Your ref: Application Number: S09_01810

Mt Piper Ash Placement Project

The Sydney West Area Health Service Centre for Population Health has reviewed the above project proposal and would like to make the following observations and recommendations.

Figure 5: Location of sensitive receivers (taken from Proponent's EA)

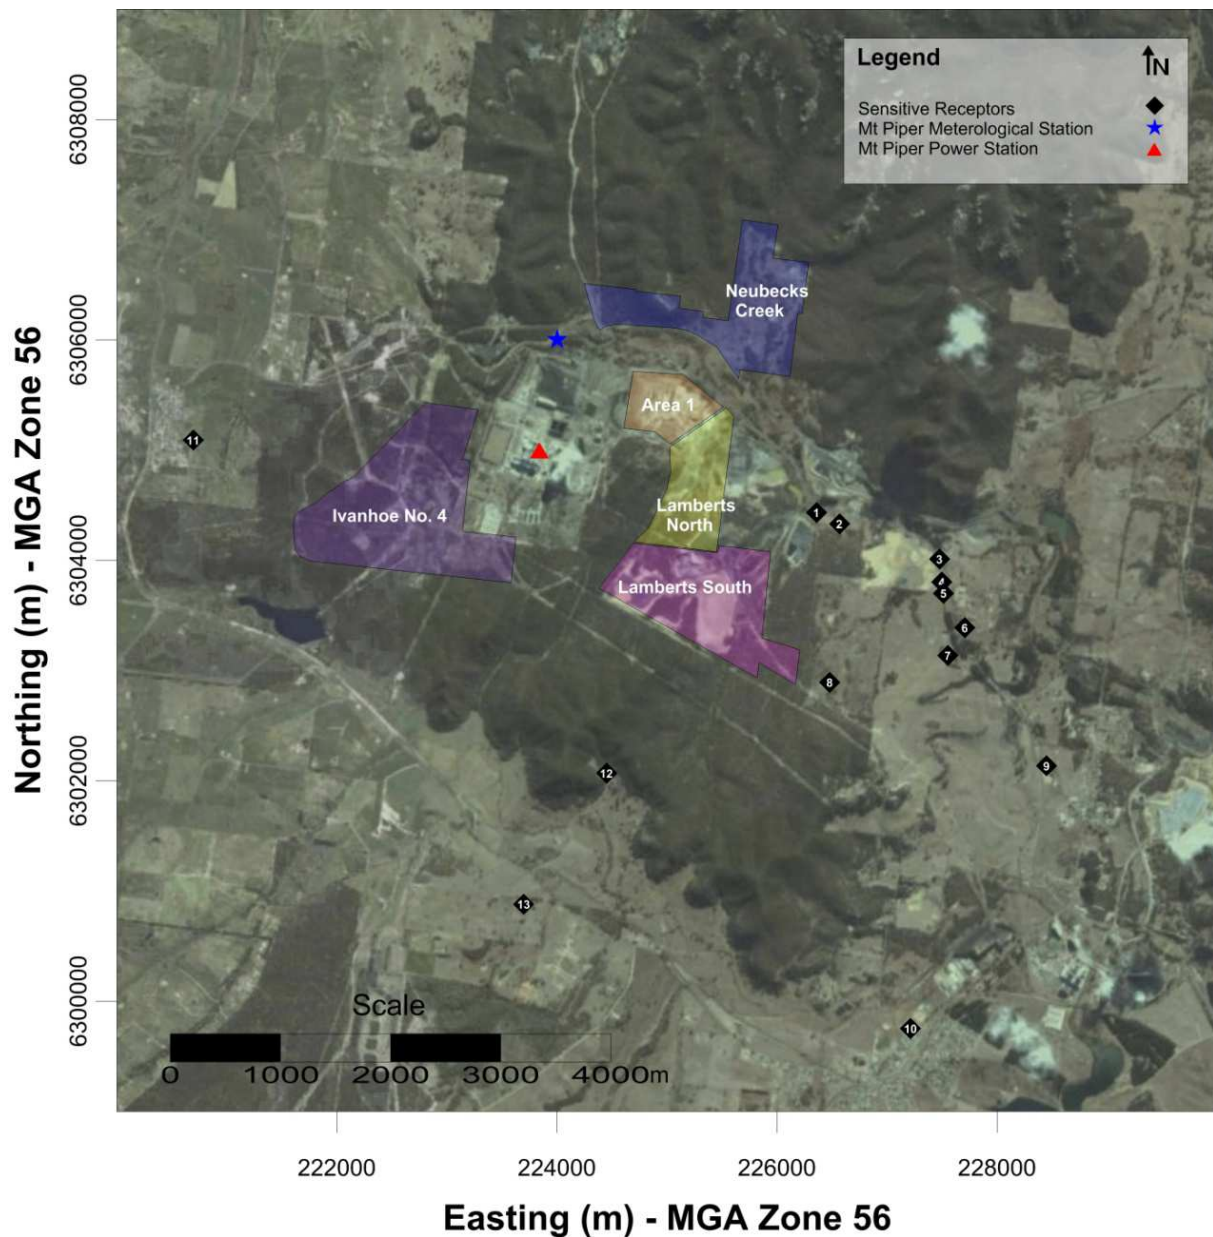
At the most sensitive receptor (1) the predicted increment annual average PM₁₀ is 4.5µg/m³ which is a substantial increase. The predicted maximum daily increment at the same location is also substantial at 15µg/m³.

1. Air quality modeling should be undertaken for each site prior to approval and include construction stage emissions .
2. Proposed mitigation measures such as use of water spray and molasses to exposed surfaces and use of water trucks on unpaved haul roads to suppress dust generation during the expansion and operation stages of the development should be required to minimise air quality impacts on local residents. If possible the mitigation measures should be linked to the proponents gaining approval to move to the next stage of the development
